City of Portland, Maine - Building or Use Permit Application
 389 Congress Street, 04101 Tel: (207) 874-8703, Fax: (207) 874-8716

PERMIT ISSUED	
Permit No: 01-1325 FEB 13 2002	Issue Date:
CBL: 032 S004001

Location of Construction: 161 Commercial St	Owner Name: Robertson John O & Sonia B Jts	Owner Address: 161 Commercial Street #100 PORTLAND	Phone:
Business Name: n/a	Contractor Name: Black Bear Sign	Contractor Address: 137 Rt 1 Scarborough	Phone: 2078835543
Lessee/Buyer's Name: n/a	Phone: n/a	Permit Type: Signs - Permanent	Zone: B-3

Past Use: Commercial / Retail Space	Proposed Use: Commercial / Retail Space; erect 3' x 15' Banner & install 3' x 3' x 3/4 mdo sign	Permit Fee:	Cost of Work: \$1,500.00	CEO District: 1
Proposed Project Description: Erect signage- 3'x5' banner on corner & 3' x 3' x 3/4 MDO Sign		FIRE DEPT: <input type="checkbox"/> Approved <input type="checkbox"/> Denied	INSPECTION: Use Group: <i>Signage</i> <i>BOCA 99</i> Signature: <i>[Signature]</i>	
		PEDESTRIAN ACTIVITIES DISTRICT (P.A.D.) Action: <input type="checkbox"/> Approved <input type="checkbox"/> Approved w/Conditions <input type="checkbox"/> Denied Signature: _____ Date: _____

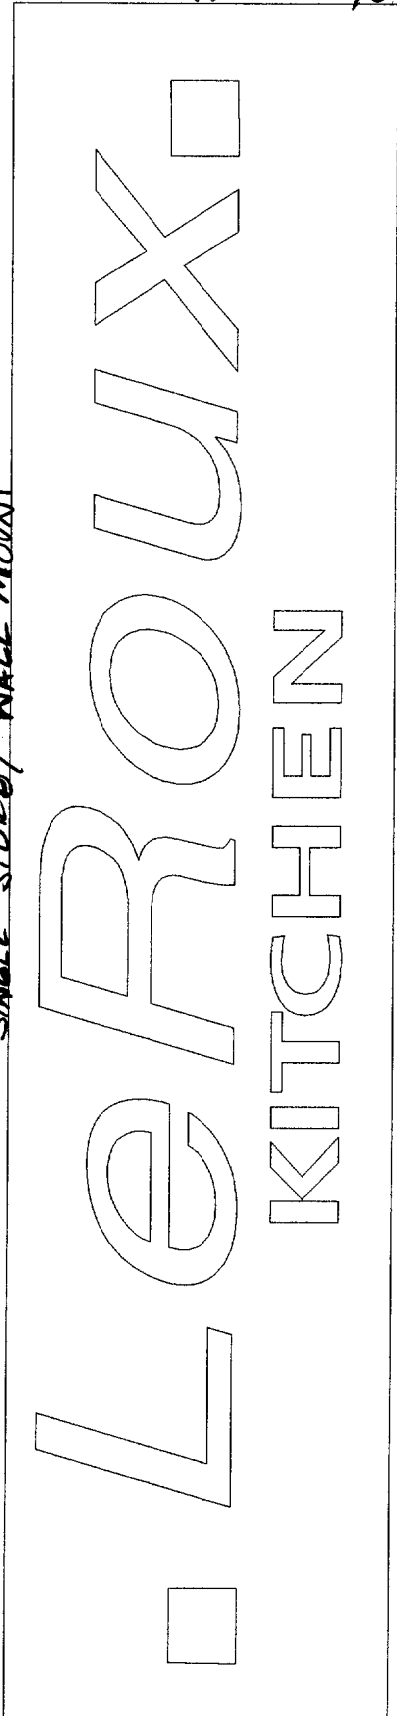
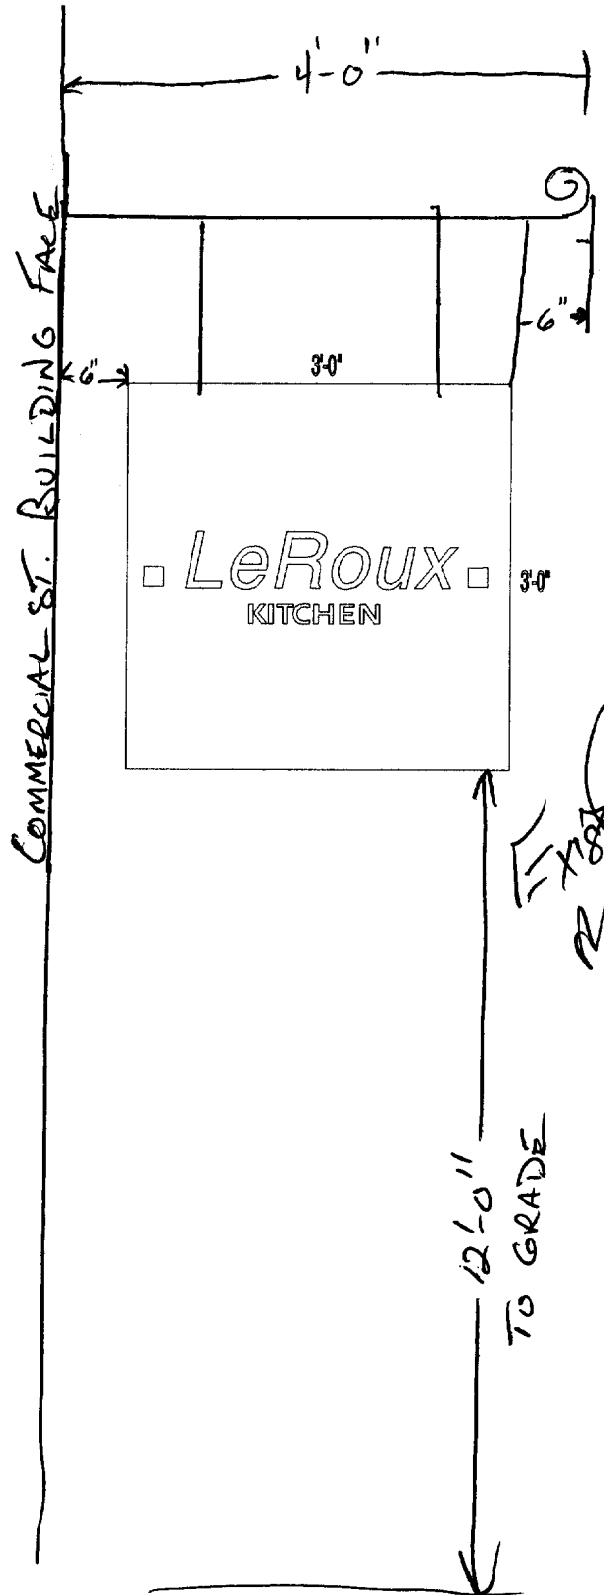
This approval is for the 3' X 3' sign only. The 3' X 15' Banner is NOT approved.

- Denied *for banner* Reason for Denial: sign does not meet H.P. standards
- Approved as submitted *→ for 3x3' sign* excessive sign
- Approved with conditions (see below)
